Appeal Decision

Appeal Ref: APP/R5510/D/23/3324073

15 Lynhurst Crescent, Uxbridge UB10 9EF

- The appeal is made under section 78 of the Town and Country Planning Act 1990 against a refusal to grant planning permission.
- The appeal is made by Mr Saad Awan against the decision of the London Borough of Hillingdon.
- The application Ref.17612/APP/2023/323, dated 2 February 2023, was refused by notice dated 27 March 2023.
- The development is a first floor side extension with a column at the rear side.

H S PLANNING LTD HEMEN SUTHAR CONSULTING ENGINEER 07940222723 hsplanningltd@yahoo.com	NORTH	PROPOSAL: Single storey side extension at FF with structural column and beam for the same at GF	DATE: 15/01/2023
		SITE: 15 LYNHURST CRESCENT	REVISION: FOR PLANNING ONLY
			ELEVATION PLAN 15/LYNH/005

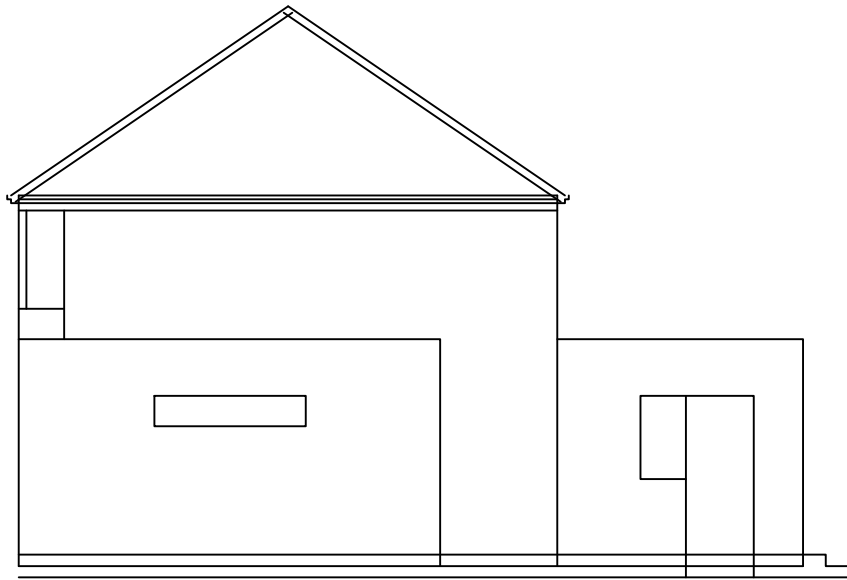
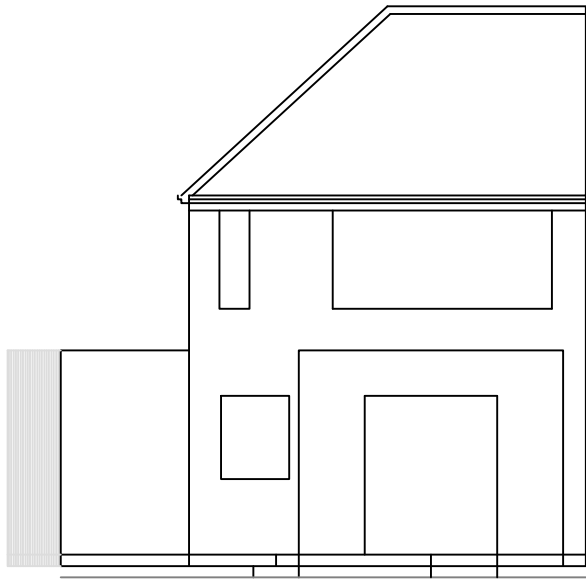
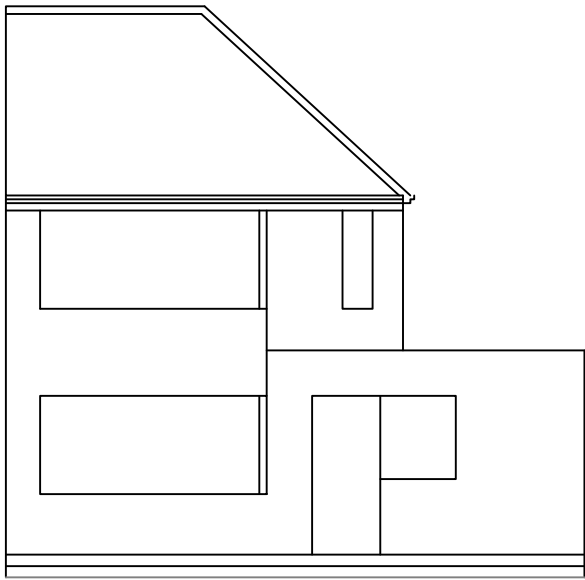
7. The development sought is a first floor extension built on the top of a side extension. It has a flat roof and projects forward of the front elevation of the main house. The flat roof is broadly similar in height to the eaves level of the main house. The front porch has been built straddling the main front elevation and encroaching partly in front of the front of the side elevation. At the rear, the first floor side extension has a void underneath it, which is supported by a corner pillar. The rear wall of the first floor side extension is flush with the main rear elevation of the house. There is a single storey rear extension and a narrow rear garden with an outbuilding.

8. The first floor side extension jars significantly with both the character and visual appearance of the main dwelling harming architectural integrity. Its flat roof profile is significantly at odds visually with the hipped roof of the main dwelling. Its projection forward of the front elevation of the main house is also awkward and gives rise to a dominant structure. This appearance is not ameliorated or significantly screened by the construction of a porch at the front of the property which has taken place.

9. The first floor extension also visually closes the gap between the appeal site and no.17 Lynhurst Crescent. It does not step in from the ground floor side extension at the appeal site and, even though there is a partial void at ground floor level, the overall appearance is dominant, cramped and overbearing. The resulting development is not subordinate to the host dwelling and increases a terracing effect with no.17, notwithstanding that there is a slight difference in orientation between the two blocks of terraces.

10. Not all extensions in the immediate area are sympathetic to the area's character but nevertheless the first floor side extension at the appeal site looks notably out of keeping with other local dwellings. The eye is drawn to its unattractive box-like and blocky outline which is out of rhythm with other dwellings. The streetscene is further harmed by the loss of views at first floor level through to the verdant vegetated area beyond the rear of the appeal site.
